Application for a Non-Material Amendment Following a Grant of Planning Permission

Loft conversion including single rear dormer and 3 front facing rooflights.

23/02555/FHA

Altering the tile cladding of the proposed rear dormer to woodgrain wall cladding.

Drawing Title	Version
Rear Elevation, Proposed	B.4

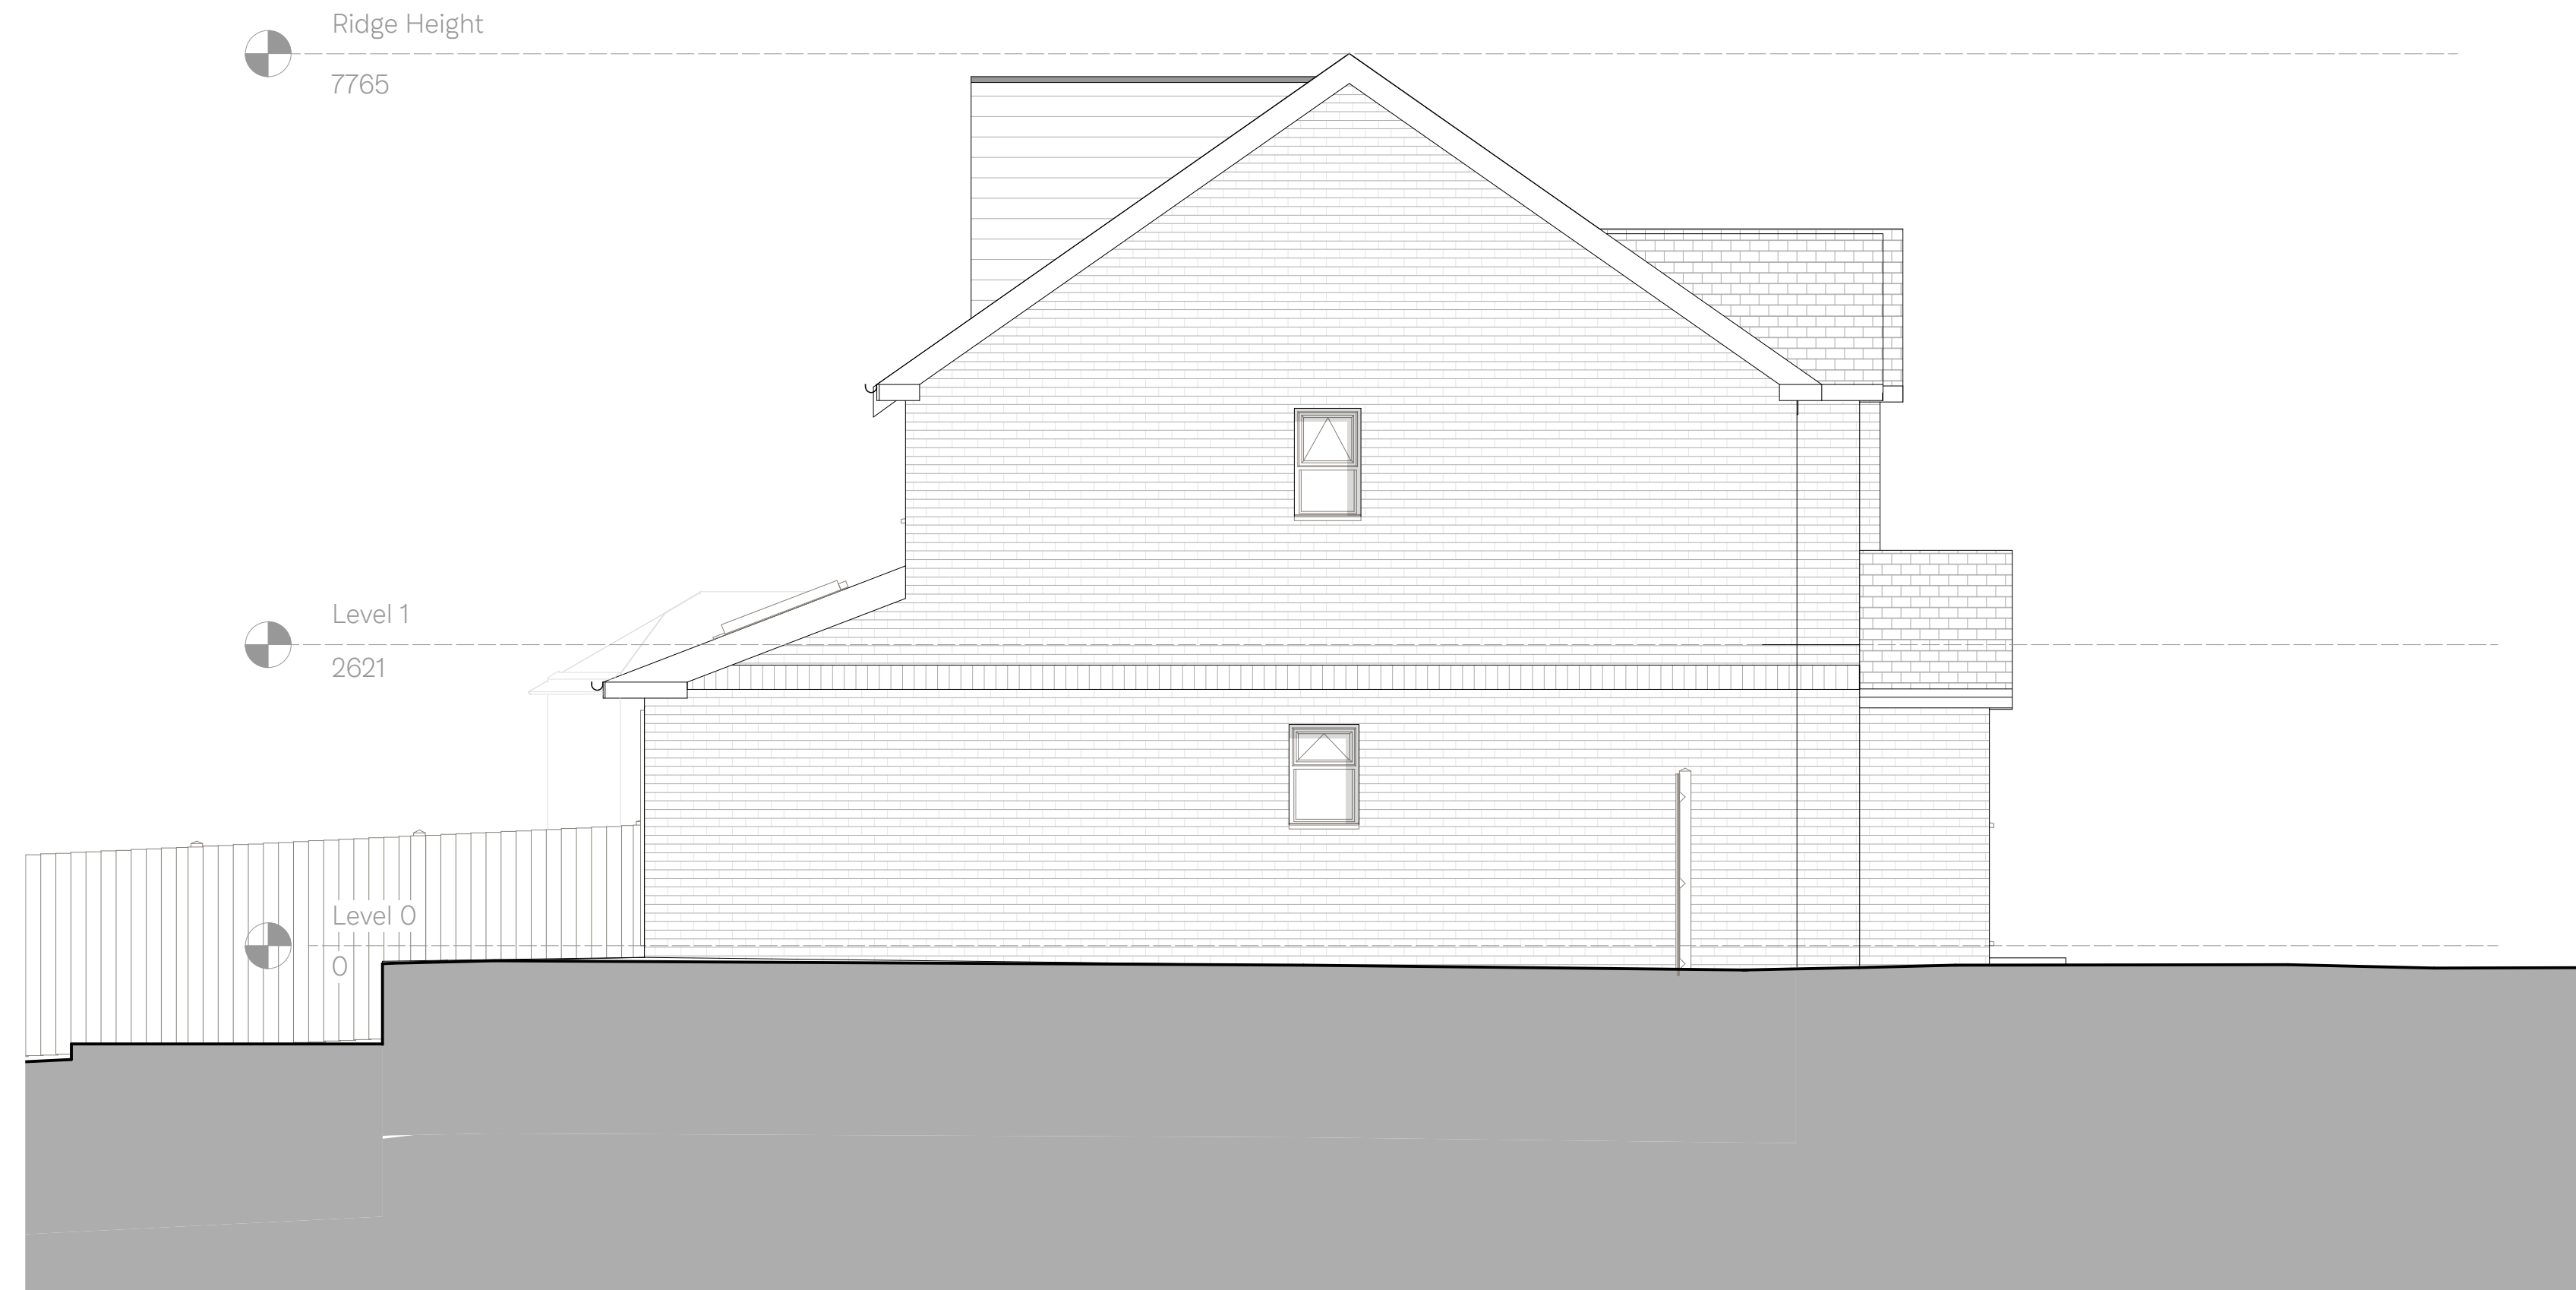
The tile cladding is being replaced with woodgrain wall cladding, as they are durable and require less maintenance.
